**KIRKLEES METROPOLITAN COUNCIL
INVESTMENT & REGENERATION SERVICE**

DELEGATED DECISION TO DETERMINE PLANNING APPLICATIONS

Reference No:	2022/62/93401/W
Site Address:	16, Bromley Road, Birkby, Huddersfield, HD2 2XR
Description:	Erection of two storey side extension, removal of 2 chimney stacks and alterations to rear window
Recommending Officer:	Laura Eddey

OFFICER REPORT

Drawing
Proposed Floor Plan

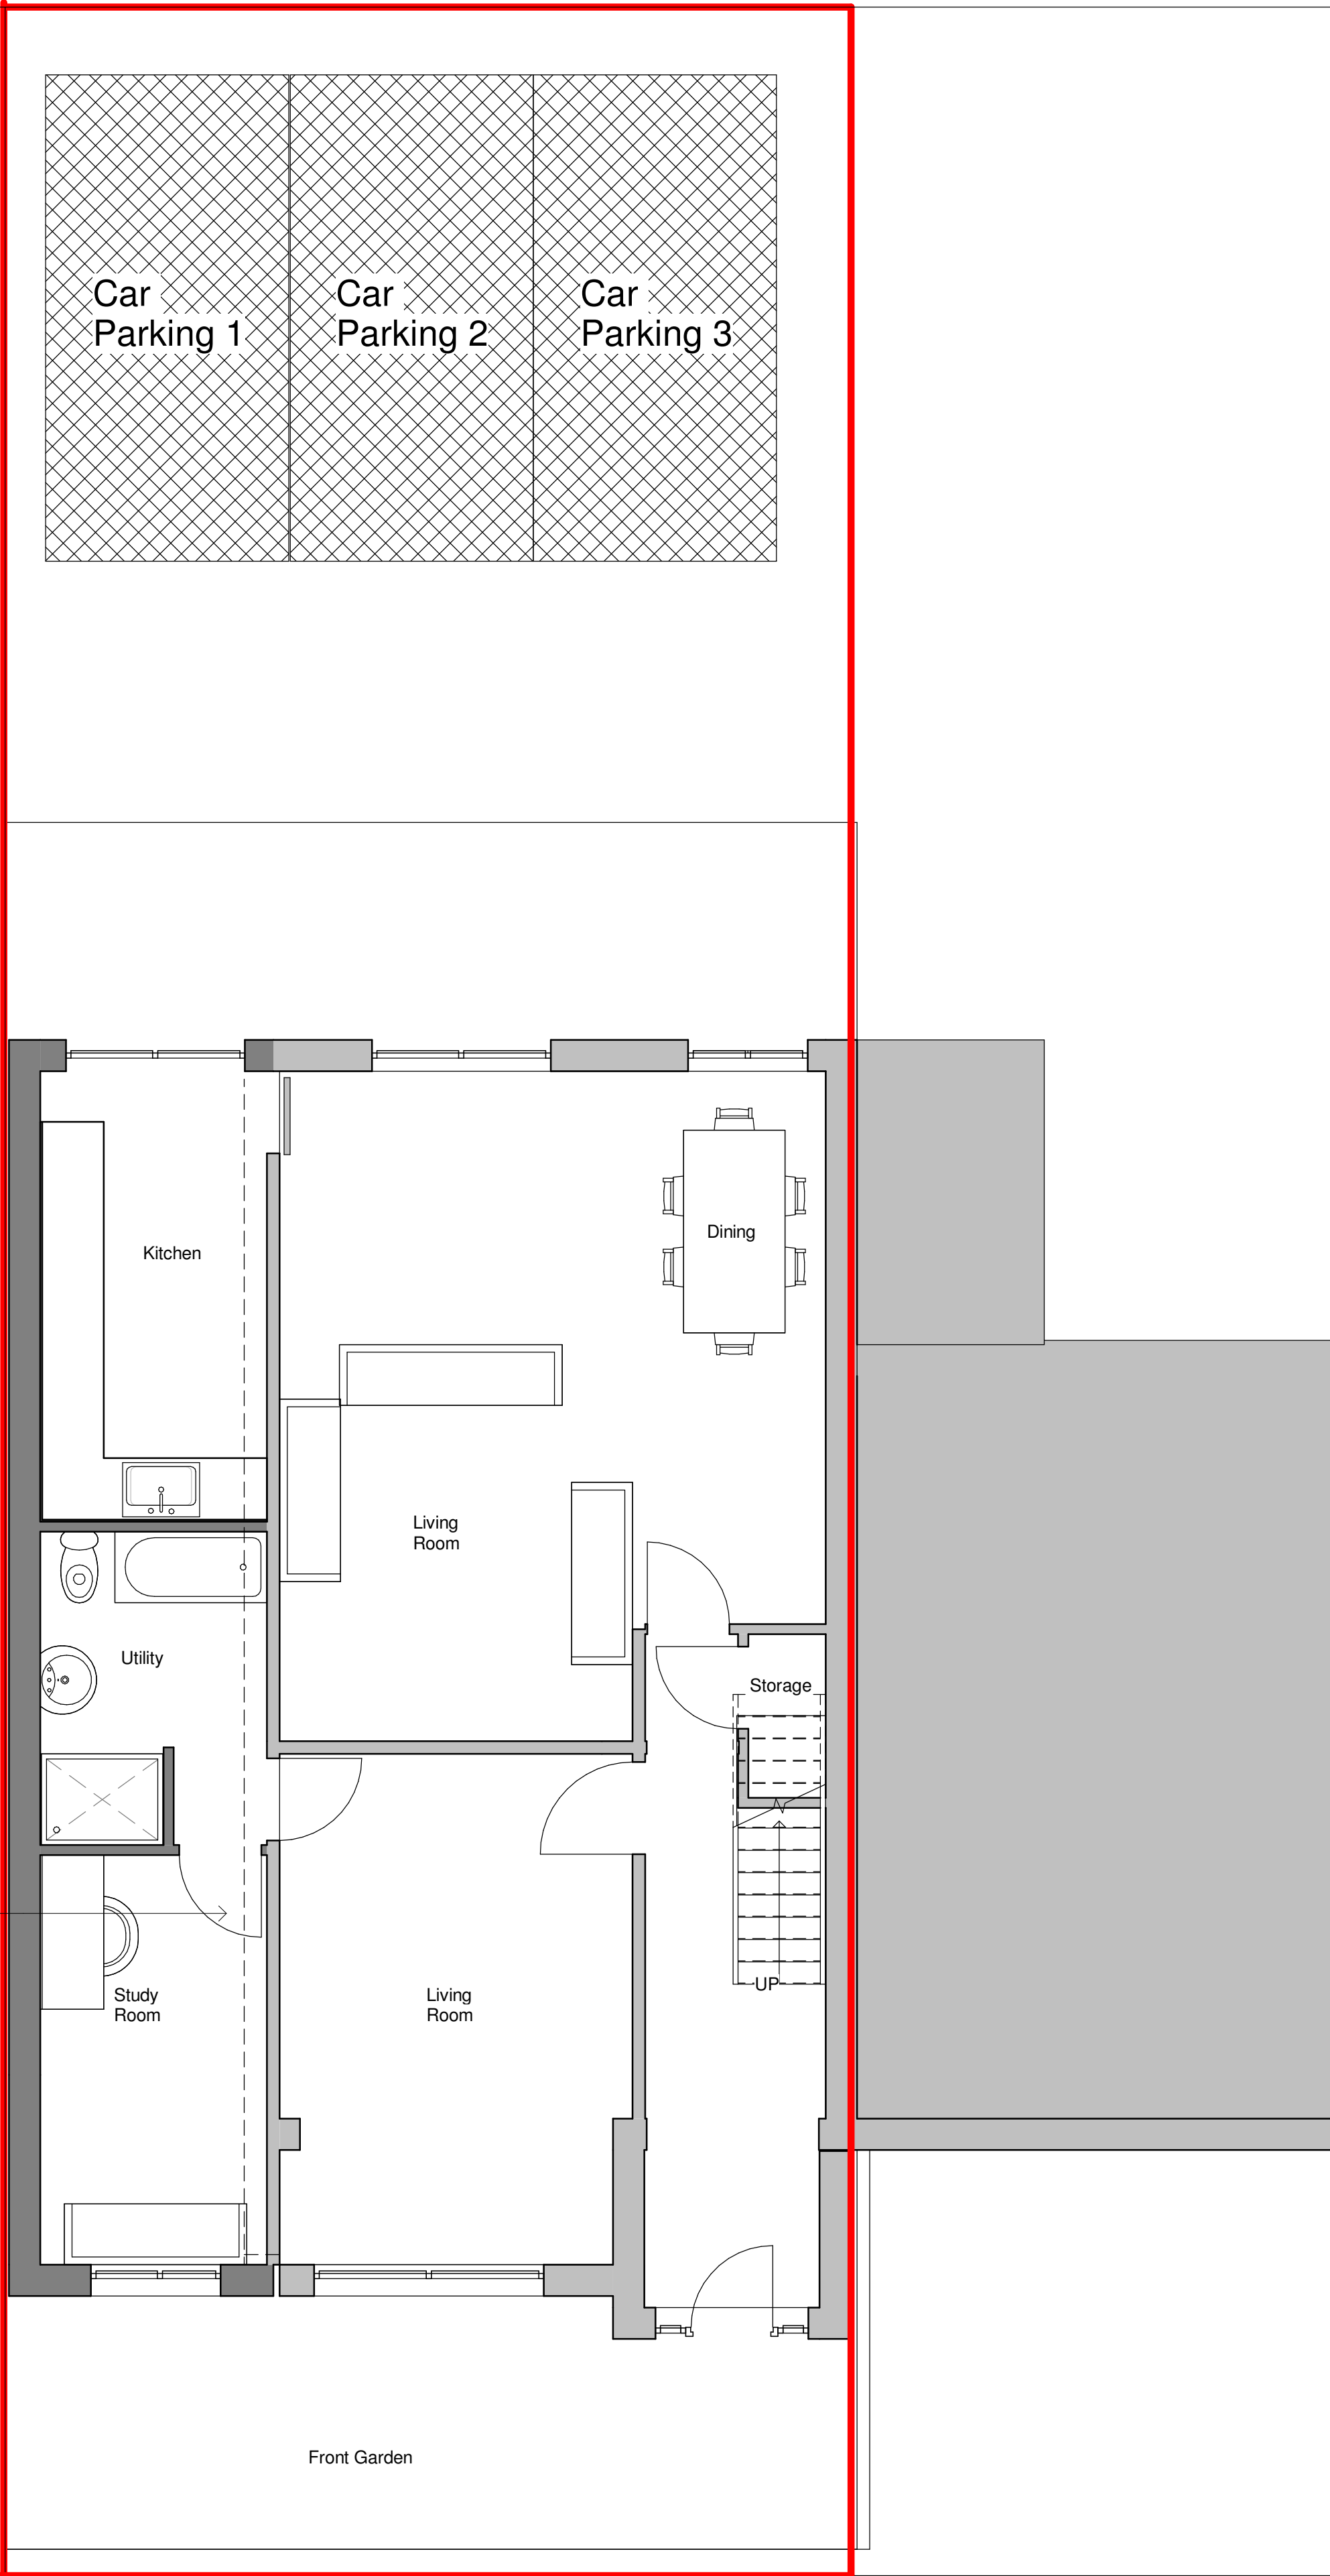
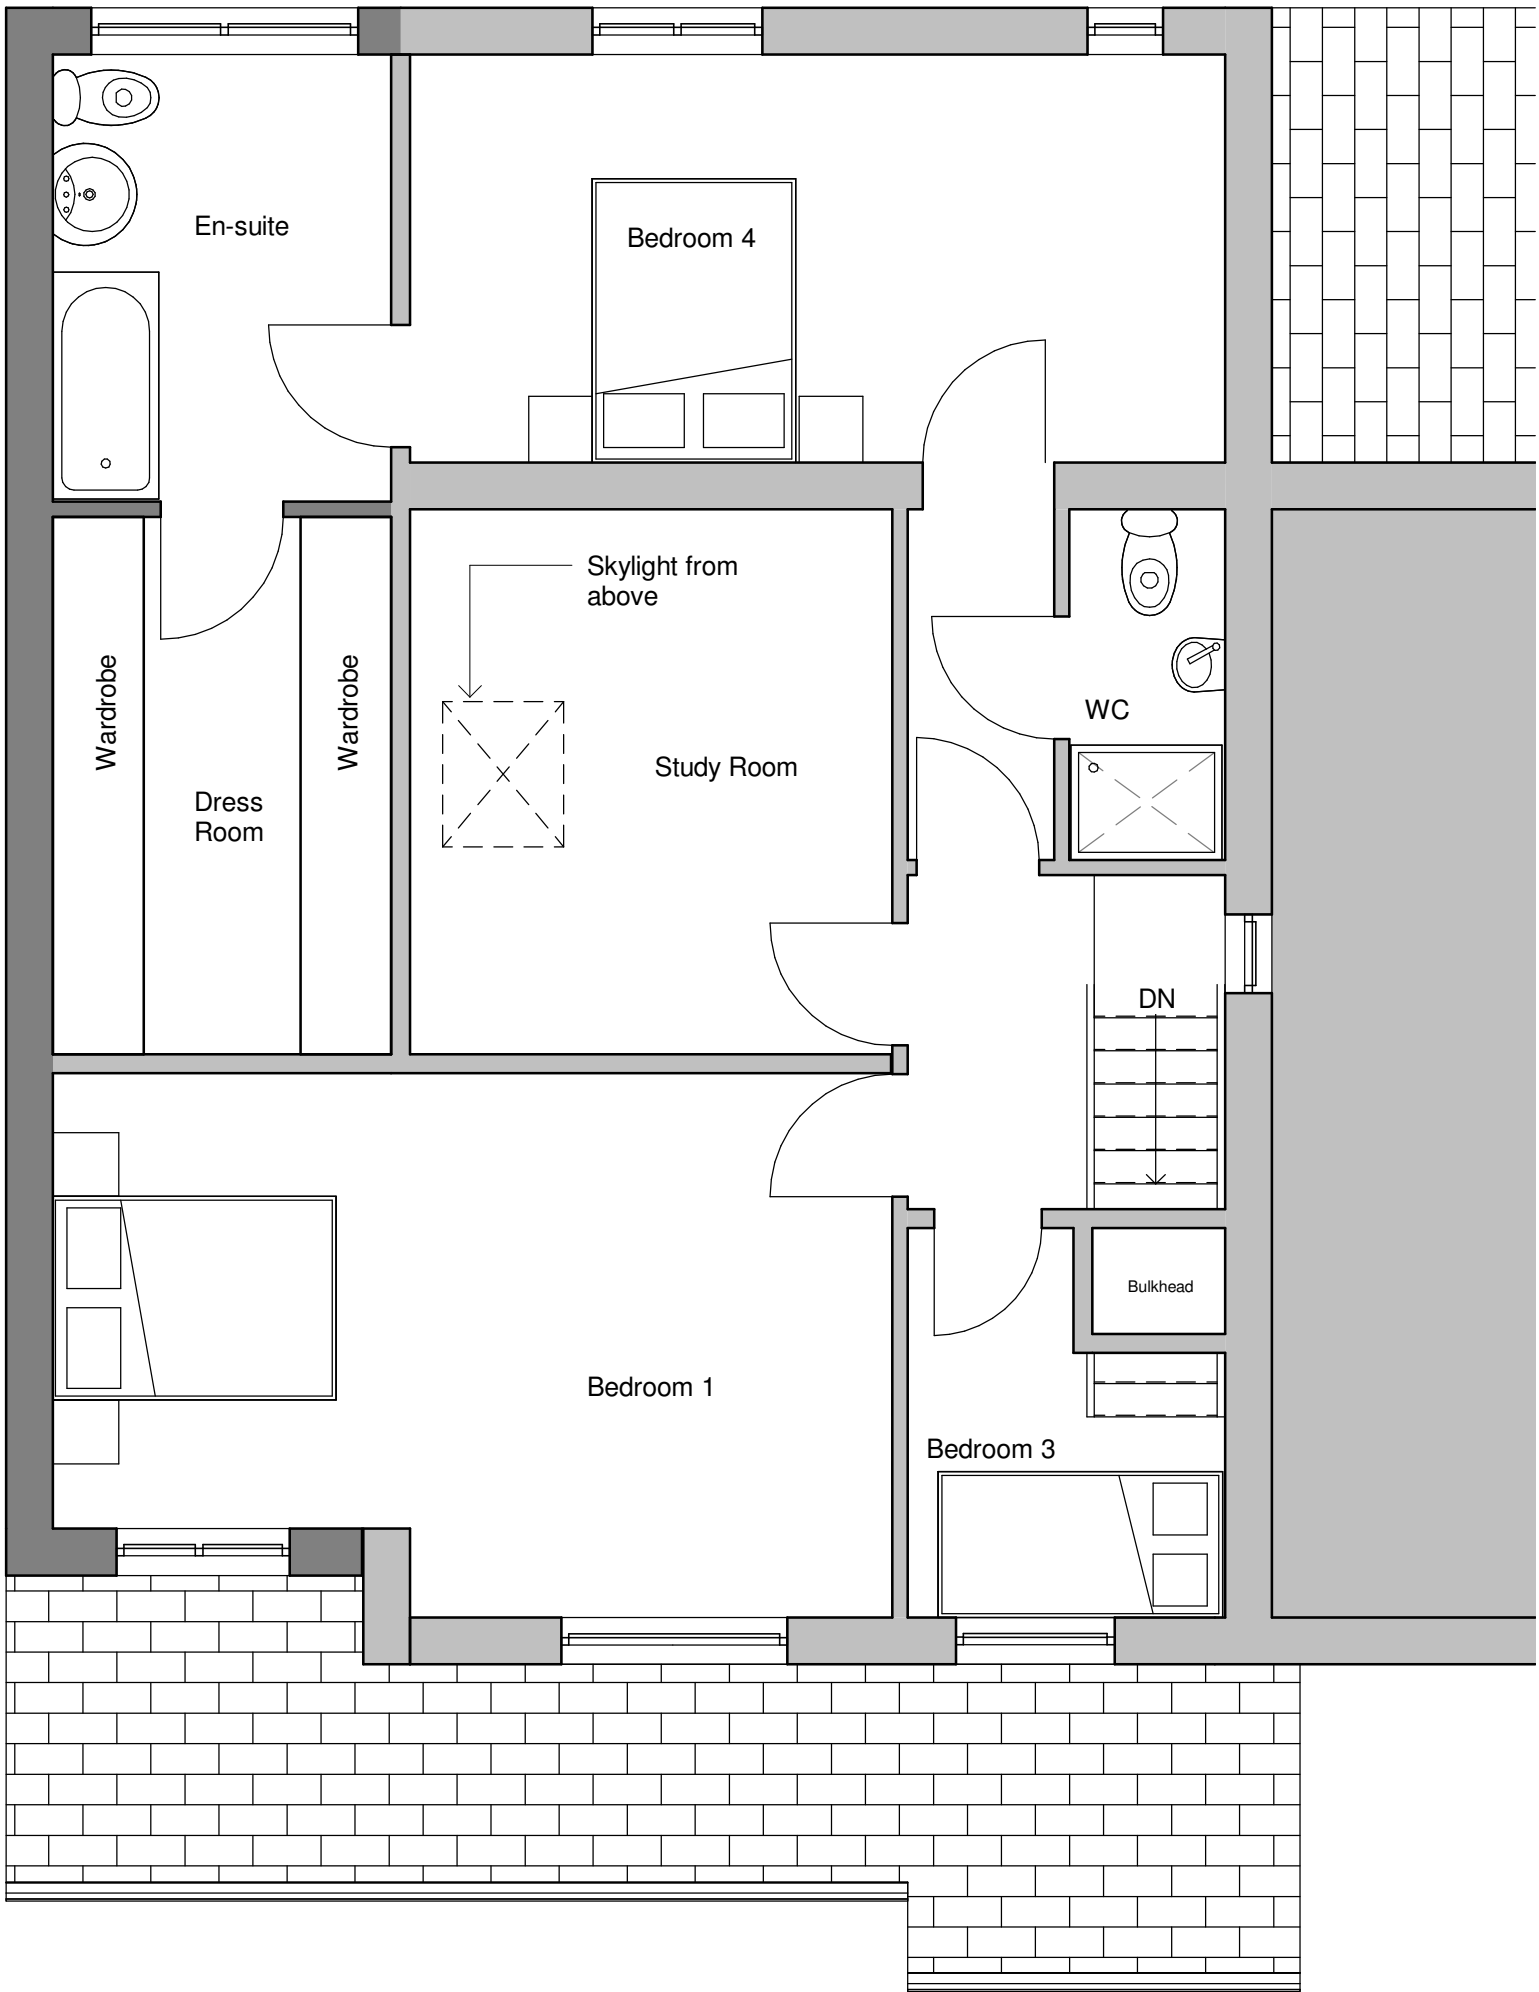
The extension will add a study room, utility room, and relocate the kitchen to the ground floor. On the first floor, the proposal covers the expansion of Bedroom 1, an ensuite for Bedroom 2 with walk in dress room. Bedroom 2 will be used as a study room, reducing the number of bedrooms to three.

The initial proposed plans provided incorrectly showed the roof as being a hipped roof design when the property has a gable-ended roof and plans for the proposed elevations were mislabelled as 'existing.' Within the interior of the property, the proposed floor plan showed an internal room with no window labelled as Bedroom 2.

New proposed plans were provided which set back the first floor front elevation and which were correctly annotated. Notwithstanding the error identified upon the existing plans, it was not considered necessary for further updated existing plans to be requested in this case and the information available to the LPA was suitable to enable a decision to be made.
